November 17, 2022

**RE: Mister Car Wash #1394, 2161 Gibson Blvd SE, ABQ
Hydrology File: M15D021B**

COMMENT RESPONSE LETTER

SHEET NUMBER
C500

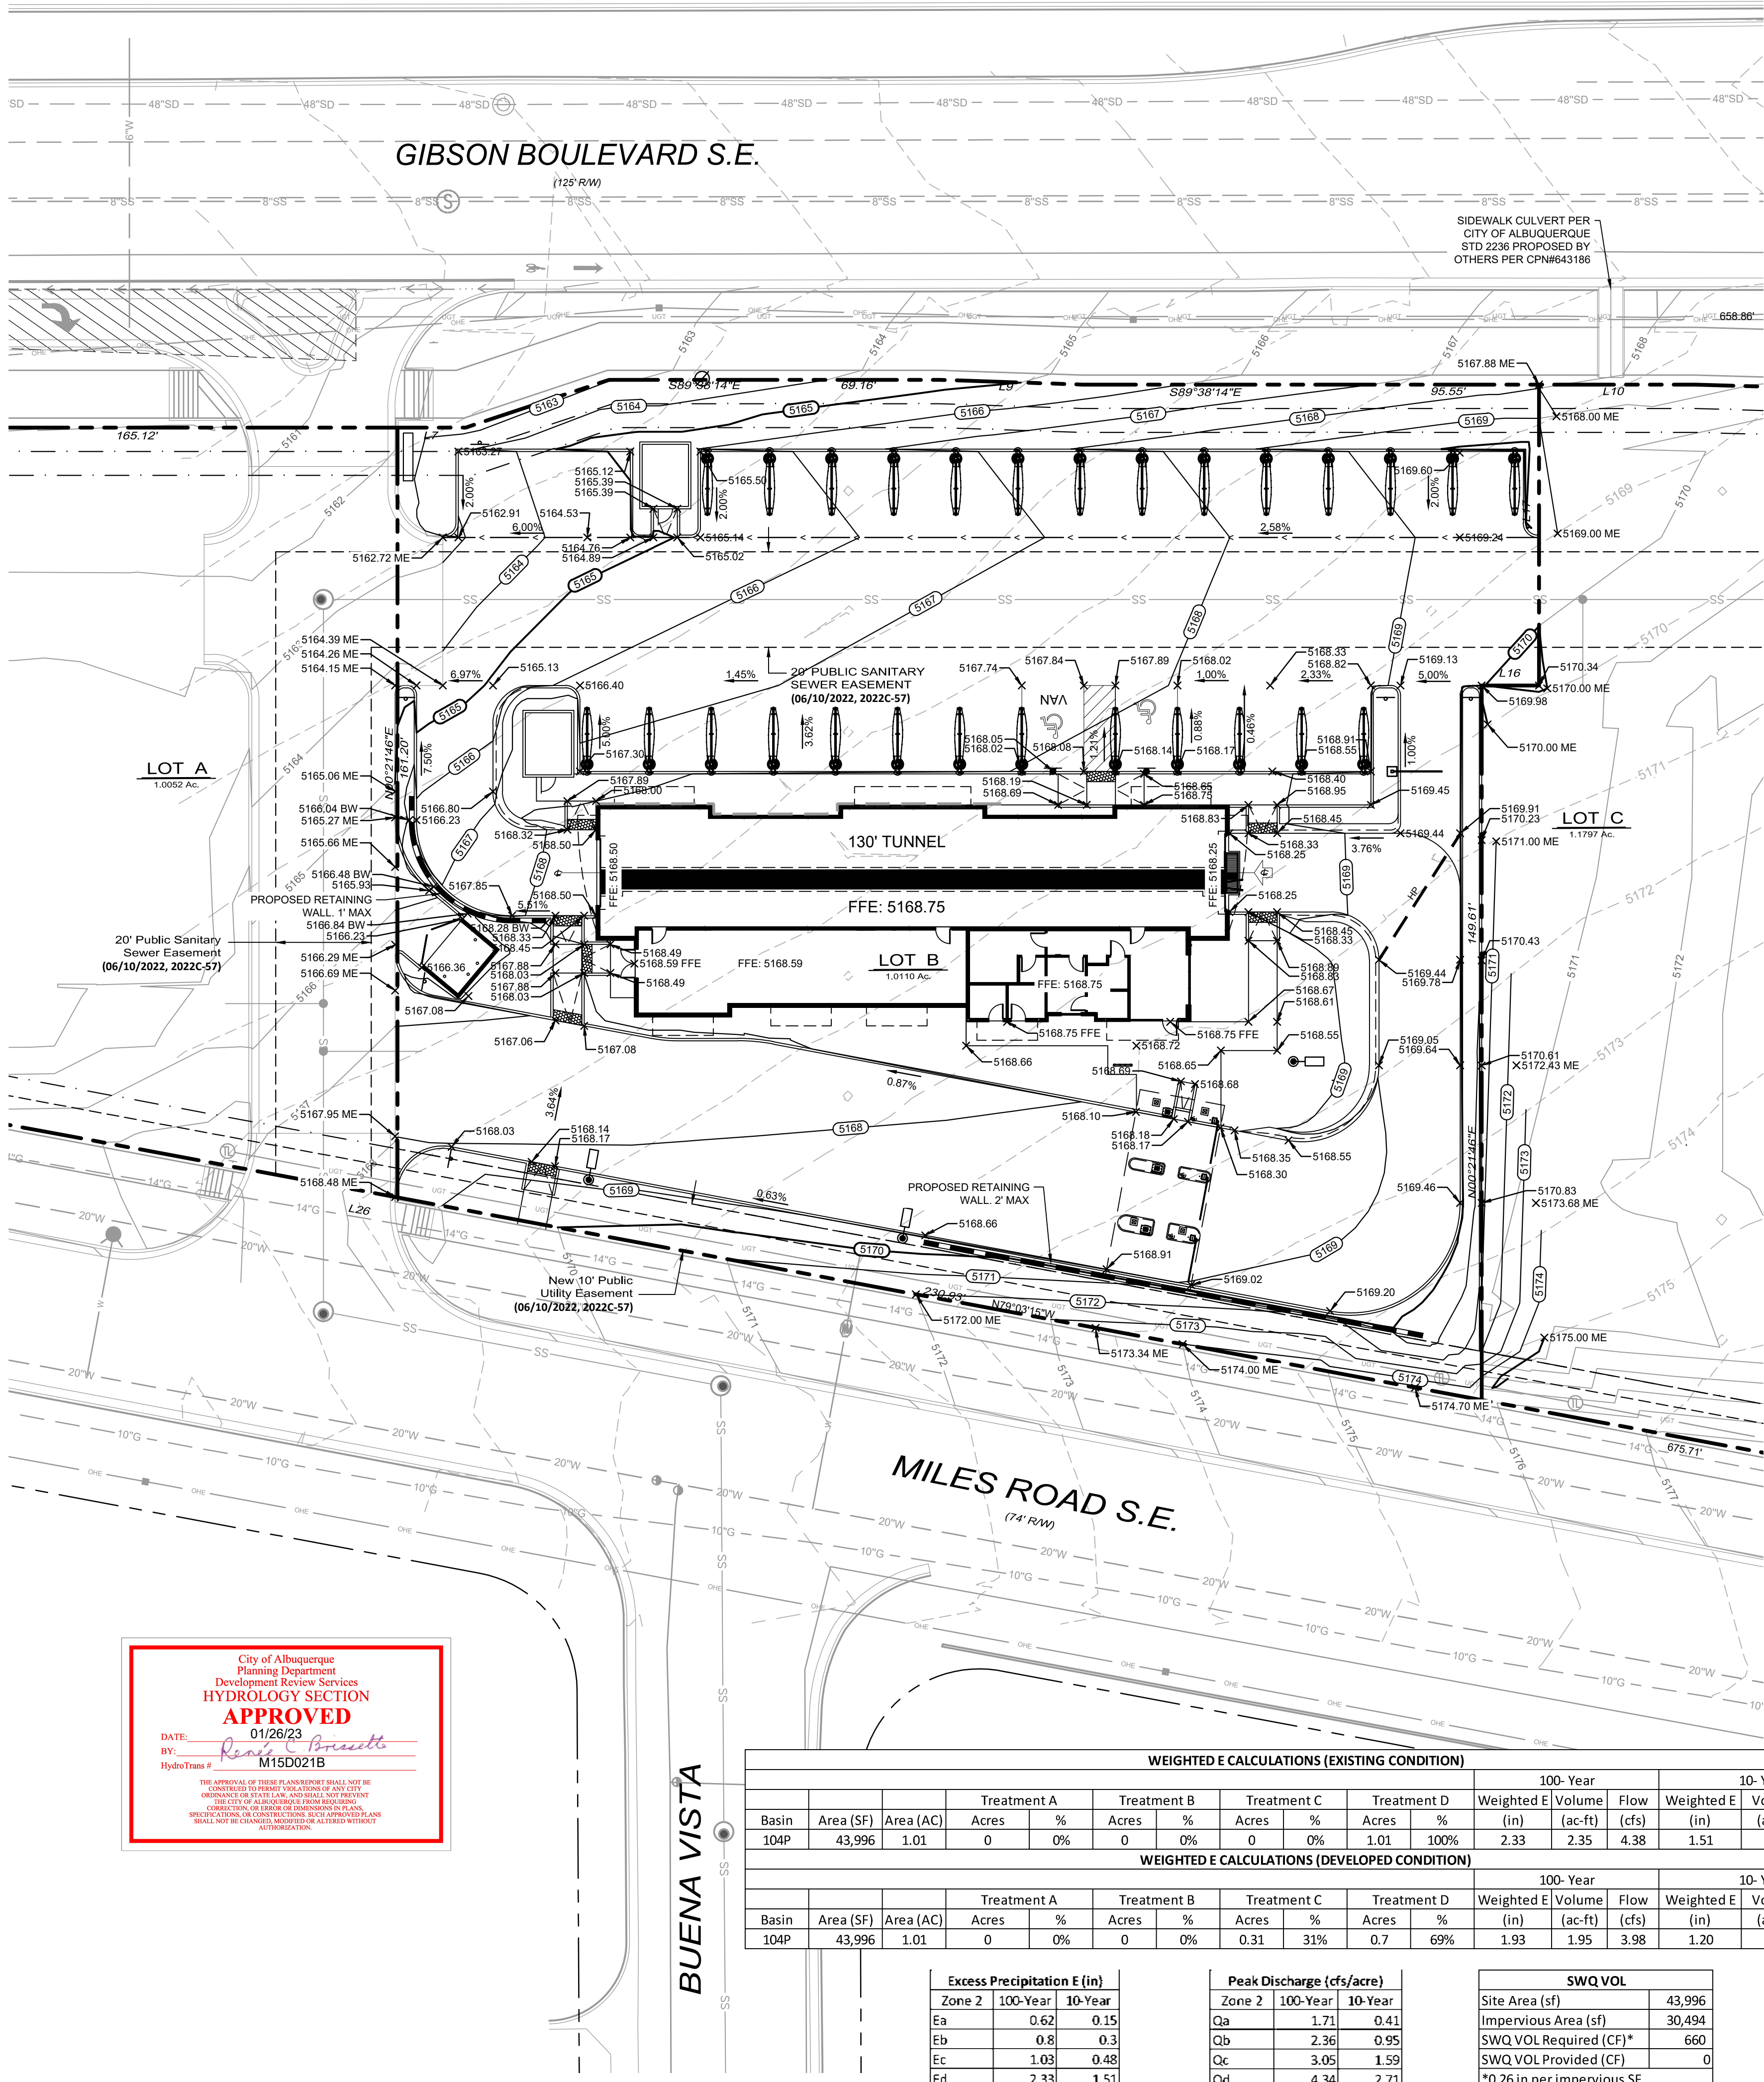
1. Per the DPM, the following must be on the Grading Plan. Please note the Grading Plan must be a stand-alone construction document.

- a. Please provide a Vicinity Map. Typically, this is the Zone Atlas. This can be downloaded in pdf format from the City of Albuquerque's website.

- b. Please provide the Benchmark information (location, description and elevation) for the survey contour information provided.

- c. Please provide the FIRM Map and flood plain note with effective date.

- d. Please provide a legal Description of the property.

2. Please reference City of Albuquerque standard detail No. 2236 – Sidewalk Culvert with Steel Plate Top at the sidewalk culvert. (see comment below for location).

3. Please add the attached SO-19 Notes.

Response: This has been added to the plan sheet.

Response: Response: This has been added to the plan sheet.

Response: This has been added to the plan sheet.

Response: This has been added under the Introduction and Project Description information.

Response: We have added a note for the proposed culvert locations on adjacent property to be installed by the developer. No culvert is proposed in this location as the runoff sheet flows in drives or over the sidewalk.

Response: These have been added to the plan sheet.

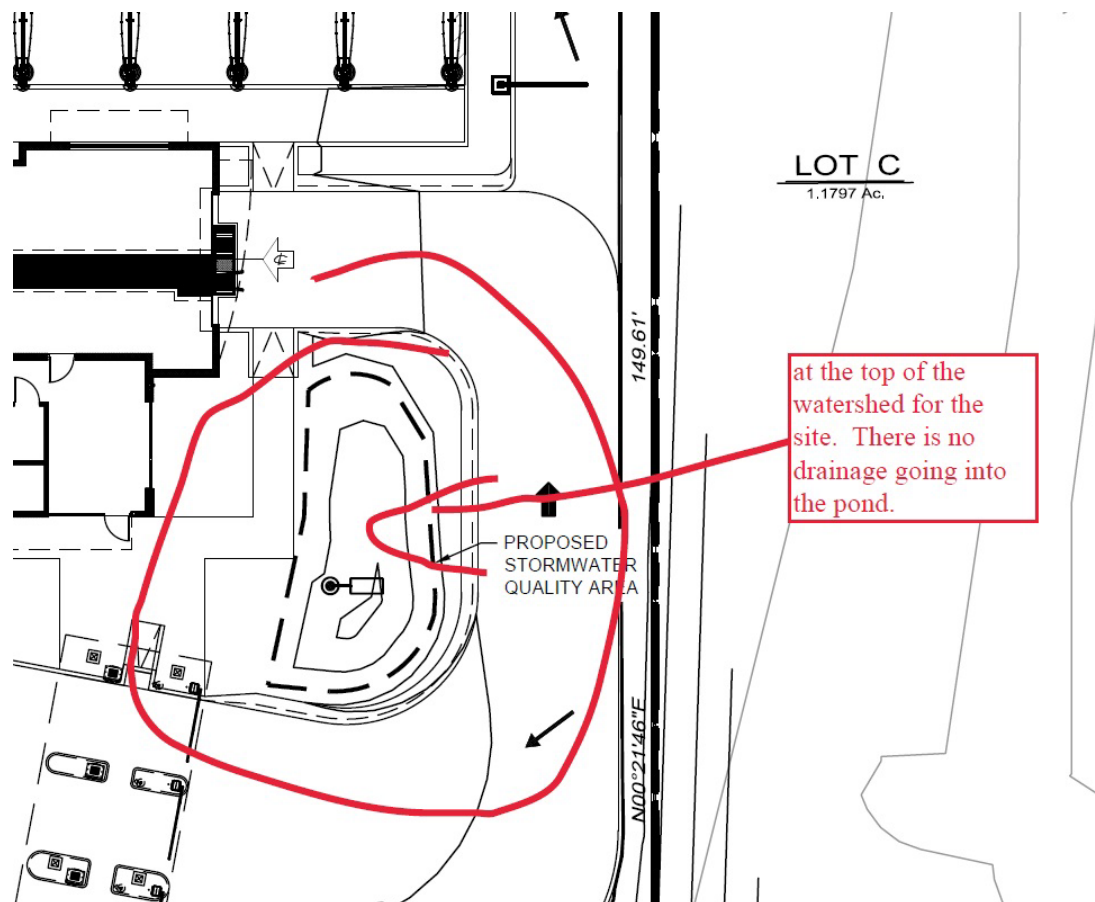
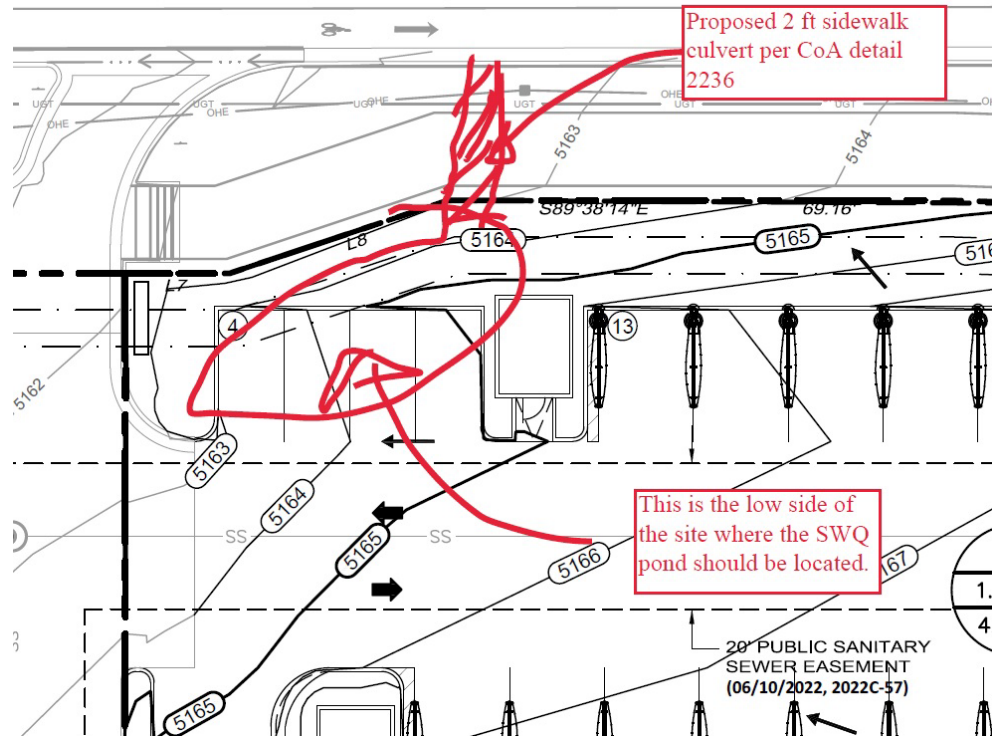
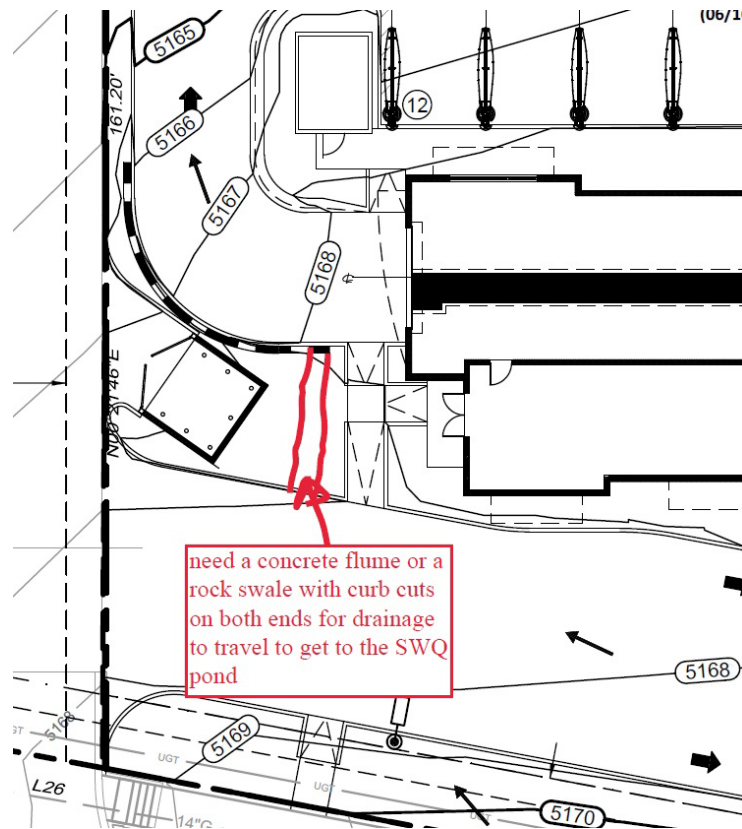
4. Please use the procedure for 40 acre and smaller basins as outlined in Development Process Manual (DPM) Article 6-2(a). Please provide both the existing conditions and proposed conditions for the 100 year-6 hour storm event.

5. Provide management onsite for the Stormwater Quality Volume (SWQV) in accordance with the Drainage Ordinance, § 14-5-2-6 (H) and the DPM Article 6-12 Stormwater Quality and Low-Impact Development for the sizing calculations. To calculate the required SWQV, multiply the impervious area draining to the SWQ pond by 0.42 inches for new development sites. Please show both the required and the provided volume.

6. The onsite drainage should be directed to the stormwater quality (SWQ) pond prior to leaving the site. Currently you have the SWQ pond on the high side of the site with little drainage going into it. Also, please show the top and bottom of the pond along with the volume for the pond. The pond also needs a spillway in the form of a sidewalk culvert at the SWQ water surface elevation on the pond side and match the existing gutter elevation in Gibson.

7. Please reference City of Albuquerque standard detail No. 2236 – Sidewalk Culvert with Steel Plate Top at the sidewalk culvert.

8. Please add either a concrete flume (channel) or a rock swale with curb cuts on either end so that the drainage can travel to the SWQ pond.

9. Please provide the weir calculations, per DPM Article 6-16(A), for the curb cuts and sidewalk culverts. A coefficient of 2.7 is typically used for the weir equation $Q = CLH^{2/3}$.

Response: Existing and Proposed Condition 100 year – 6 hour flows have been added to the sheet.

Response: As this is a redevelopment site, we have provided the SWQV calculations based on 0.26 inches, and this has been added to the plan sheet.

Response: The SEC of the site and the area adjacent to the east side of the building flows into the SWQ area. The areas to the south and west sides of the building flows across landscape prior entering the paved areas and discharging to Gibson Blvd. There are numerous challenges to providing the SWQ area in the location suggested in the comments due to the sites grading, access drive, and parking demands. Please see attached waiver letter for remaining SWQ volume.

Response: Understood that this detail is to be used if culverts are required.

Response: This is the transformer pad location so a flume cannot be provided across the island behind the dumpster.

Response: The drainage sheet flows over the sidewalk or in the driveways to Gibson.
